Your ref: 2020/0260
Our ref:
Date: 24th April 2020

Address: 27 Calder Avenue Billington BB7 9NQ

Description: Conversion of existing dwelling into two separate dwellings.

PROPOSED BASIC SITE PLAN 1:100

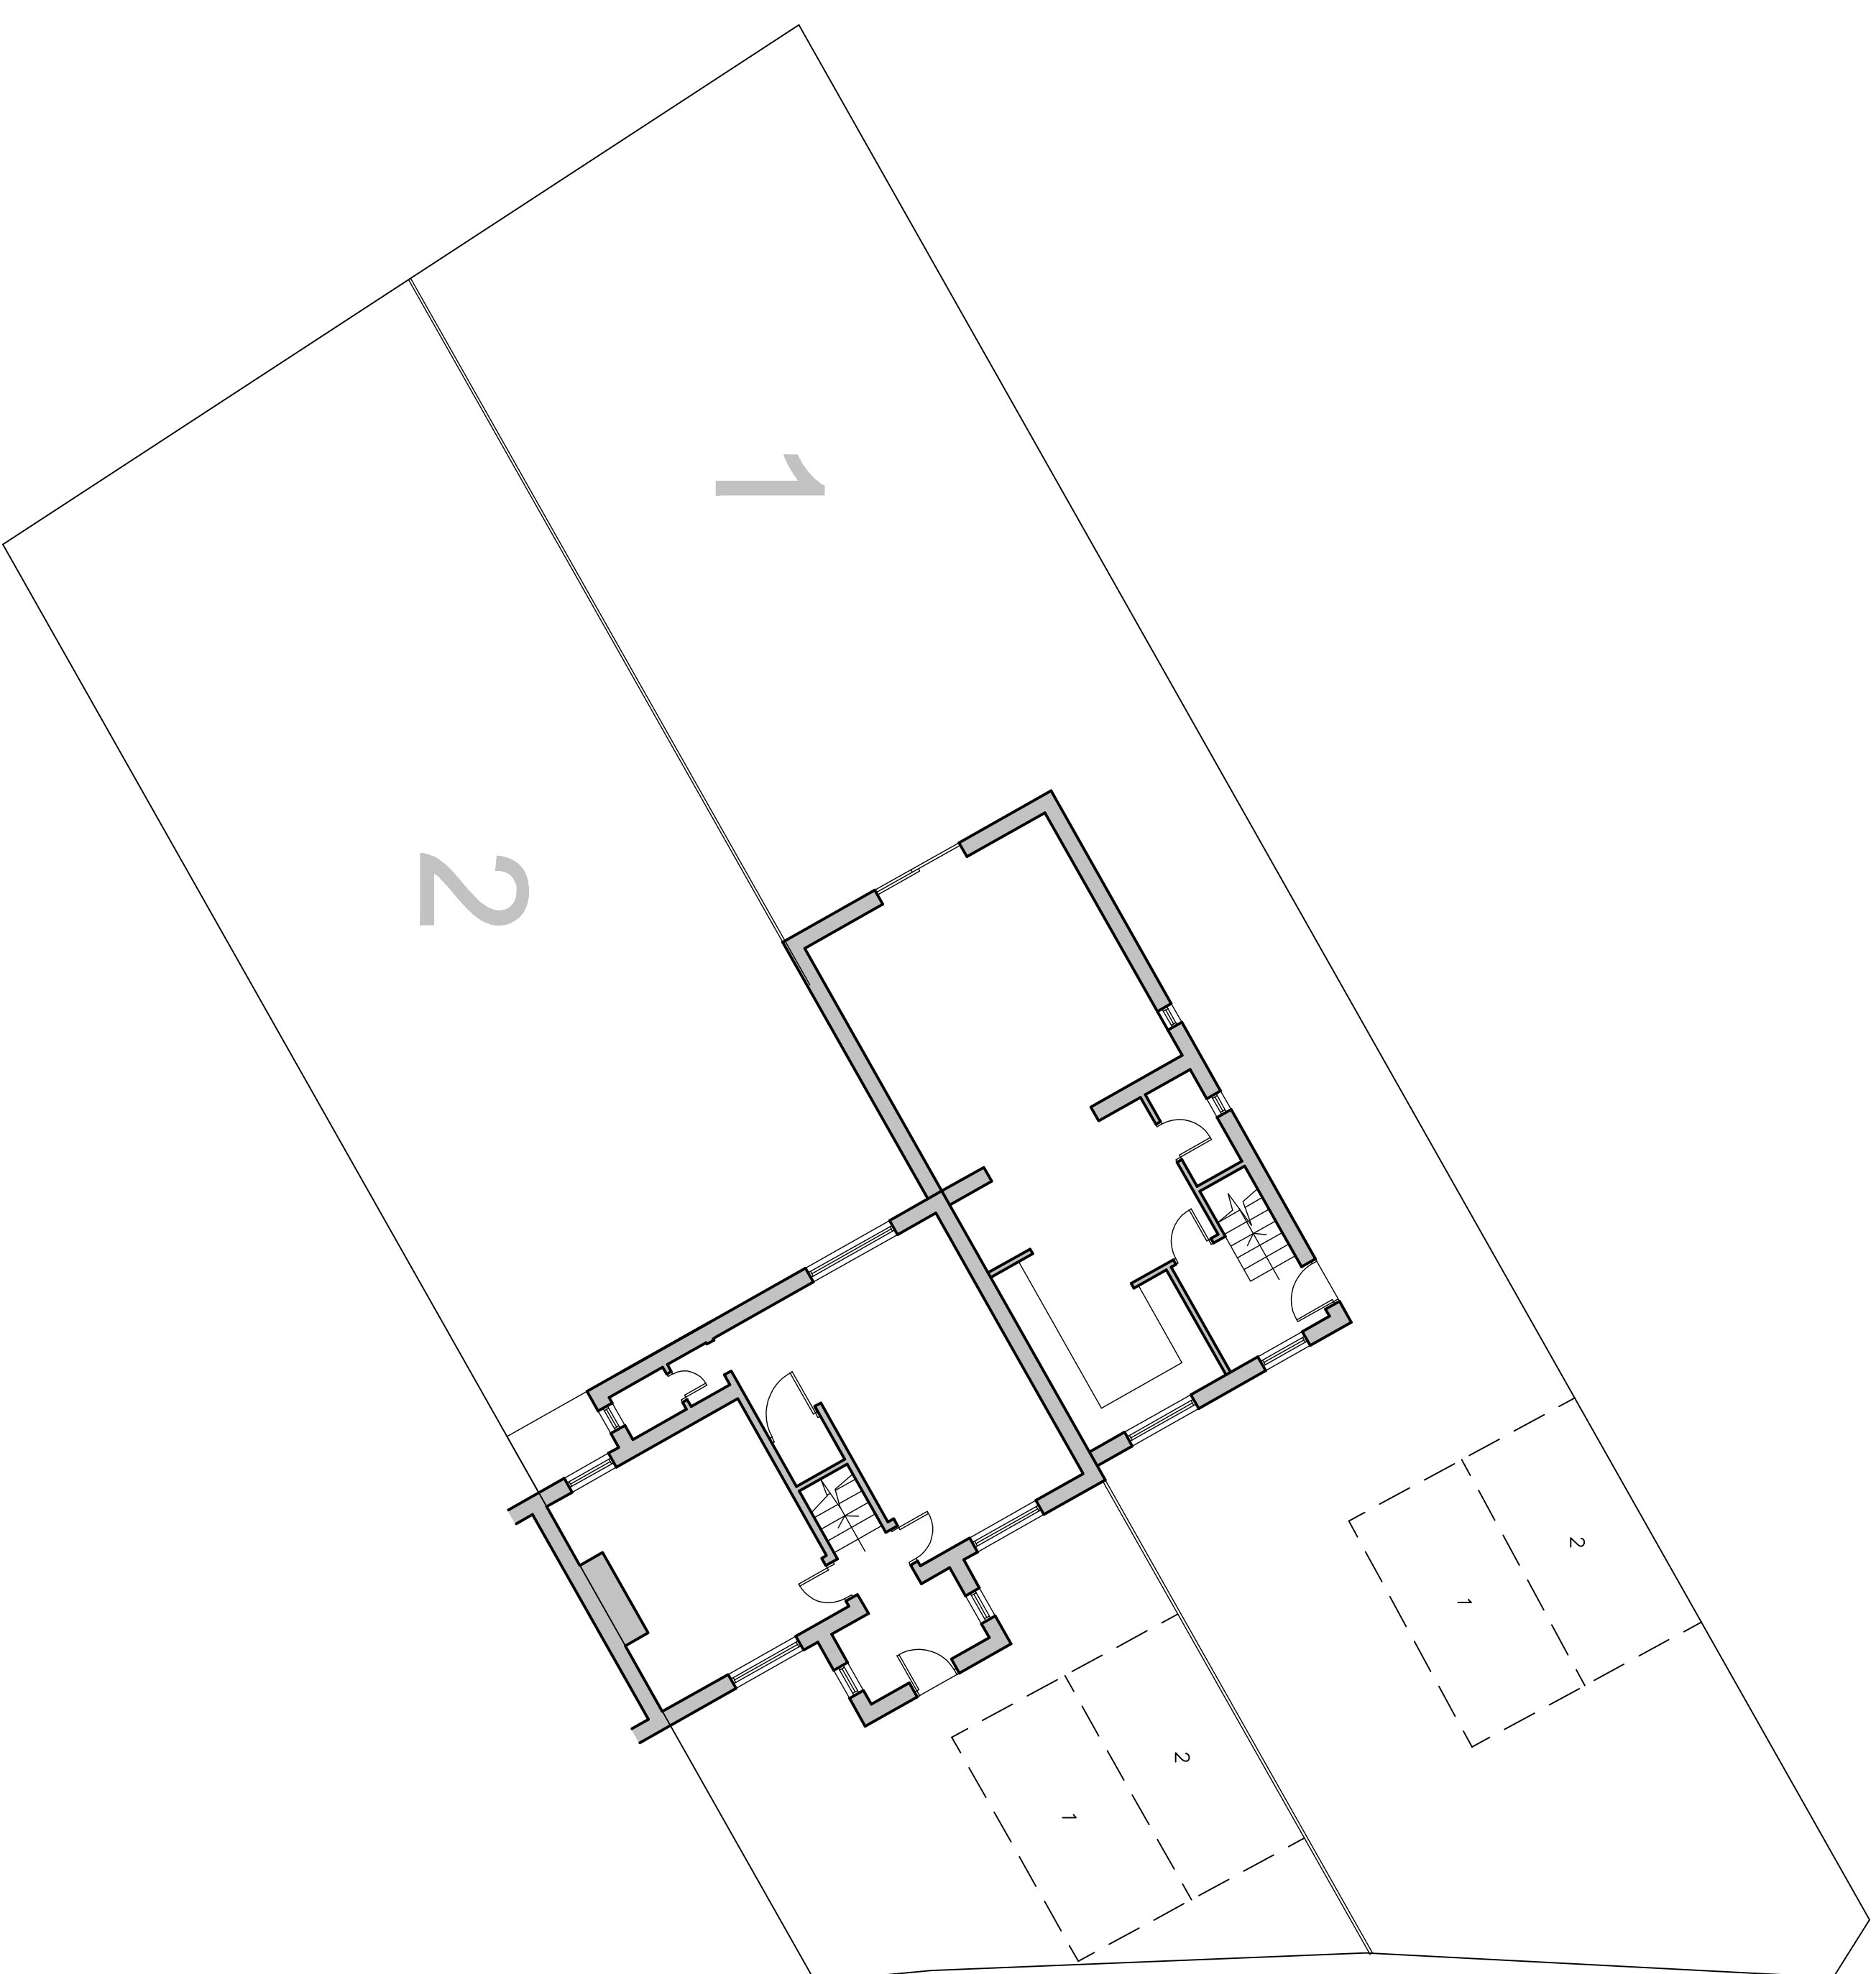
Whilst a plan has been drawn showing the location of 4 parking spaces it is noted the two of them are adjacent to fences or other obstructions which will hinder the opening of the car doors. Additionally there is concern regarding the usability of the spaces at the dwelling marked as 2 on the Site Plan.

In order to progress the applications we would look for the widening of the spaces adjacent to the fence by 0.6m, and a swept path analysis showing that each of the 4 spaces can be accessed from the adopted highway.
